**From:** [Holly Erdman](#)  
**To:** [Kelly Bacon \(CD\)](#)  
**Subject:** RE: BL-22-00017 Rosenberry - Notice of Application  
**Date:** Wednesday, August 24, 2022 4:32:57 PM

**From:** Kelly Bacon (CD) <kelly.bacon.cd@co.kittitas.wa.us>  
**Sent:** Thursday, August 11, 2022 4:30 PM  
**To:** Jeremy Larson <jeremy.larson@co.kittitas.wa.us>; Steph Mifflin <stephanie.mifflin@co.kittitas.wa.us>; Kelee Hodges <kelee.hodges.pw@co.kittitas.wa.us>; Holly Erdman <Holly.erdman@co.kittitas.wa.us>; Jesse Cox <jesse.cox@co.kittitas.wa.us>  
**Subject:** BL-22-00017 Rosenberry - Notice of Application

Please review the following Boundary Line Adjustment application: BL-22-00017. Any comments need to be submitted **by 5pm on August 26, 2022**. Please let me know if there are any questions.

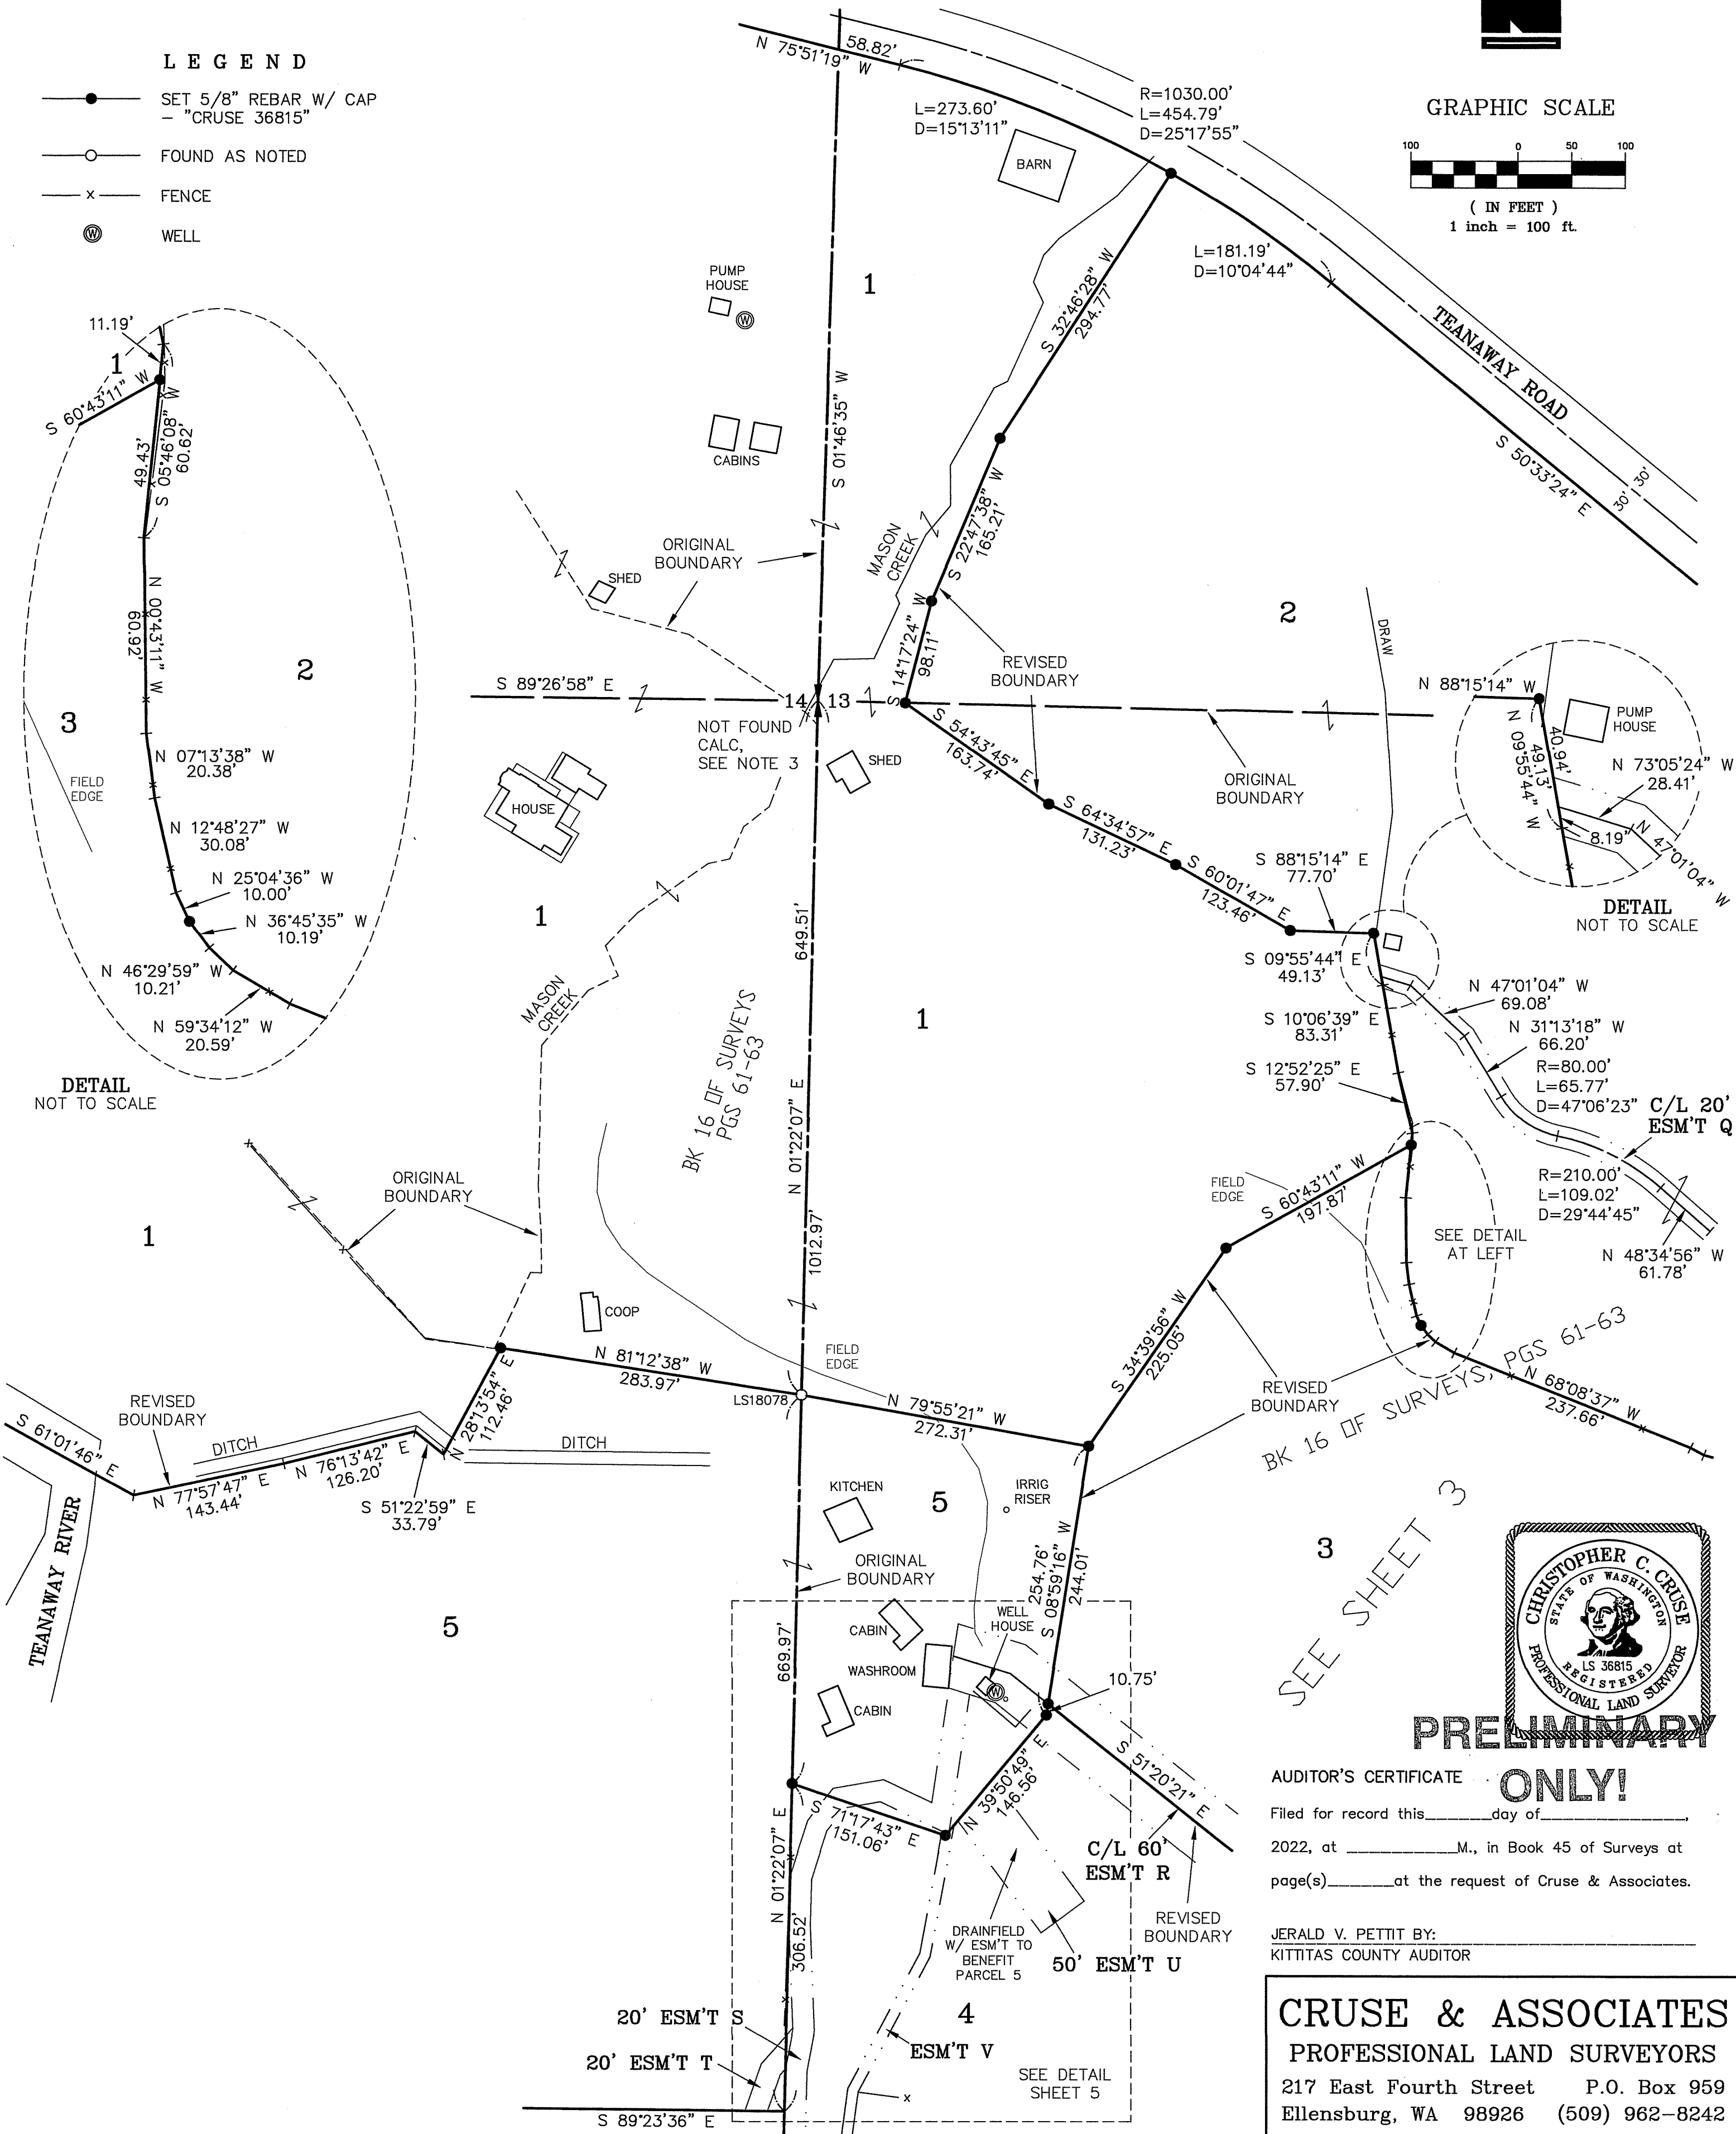
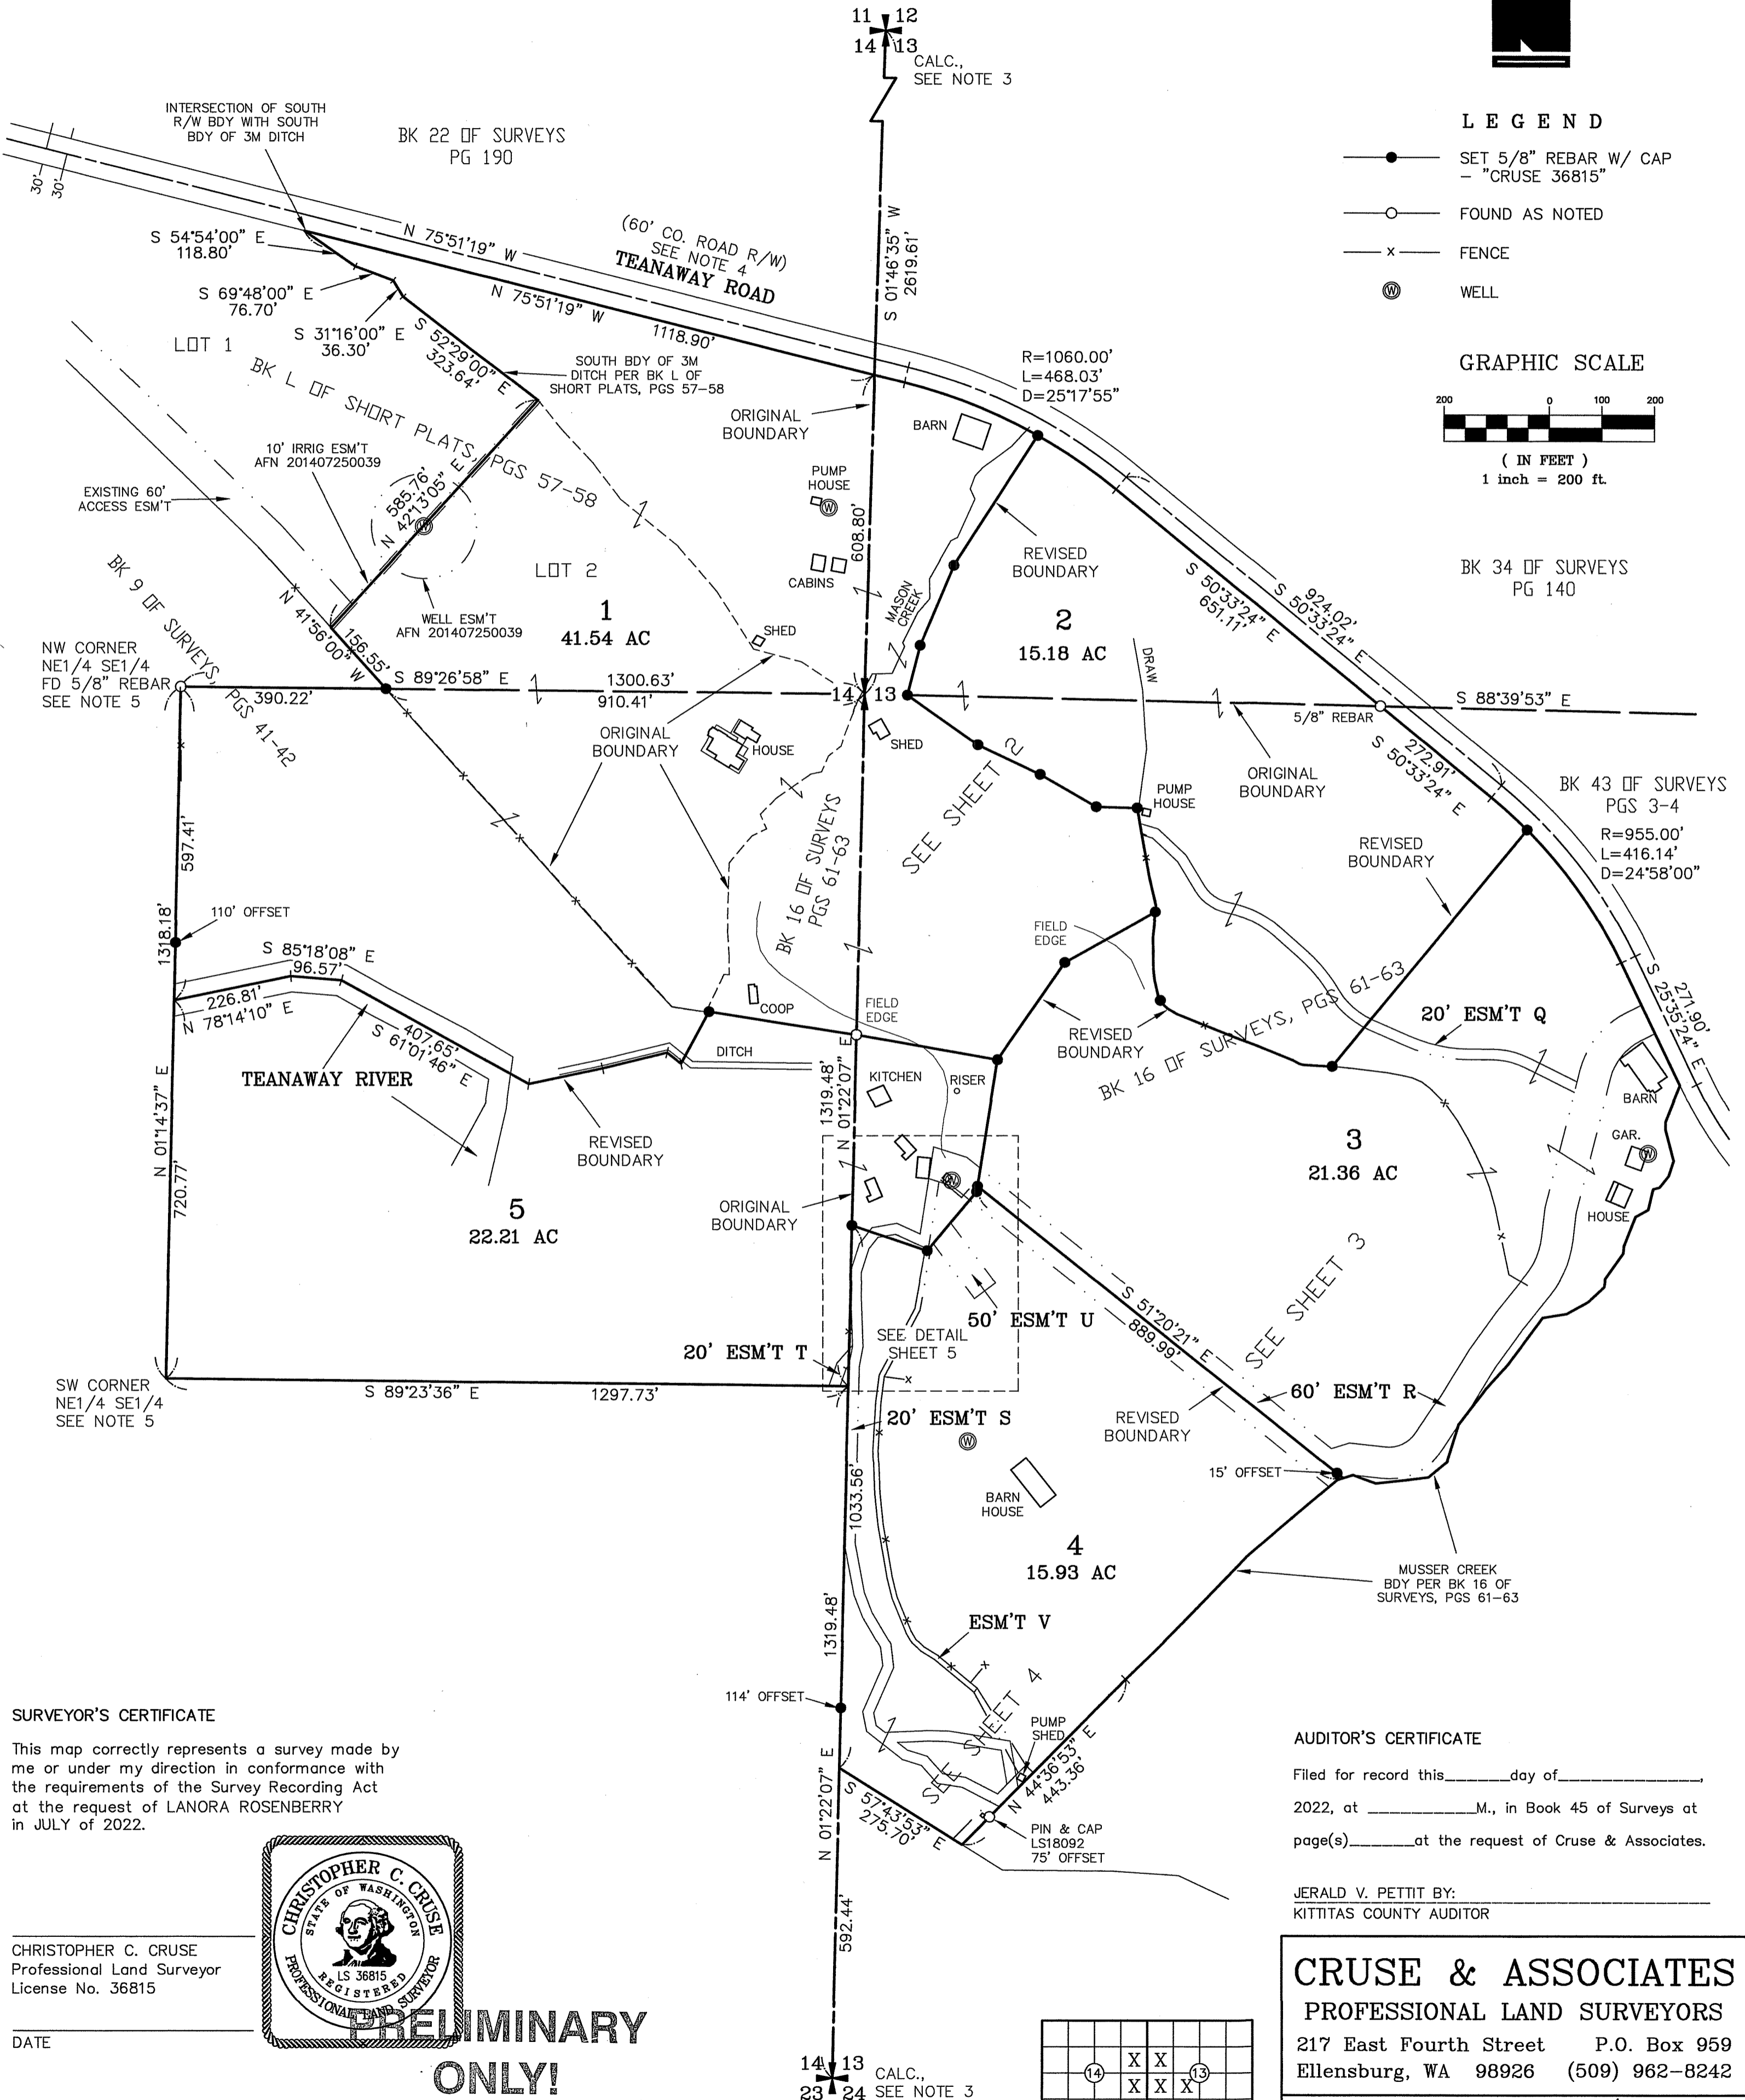
1. What is the distance the well is from the property line on the new proposed property lines of parcel 5?
2. What is the distance that the septic tanks and drainfield are from the proposed property line between parcel 4 and parcel 5?
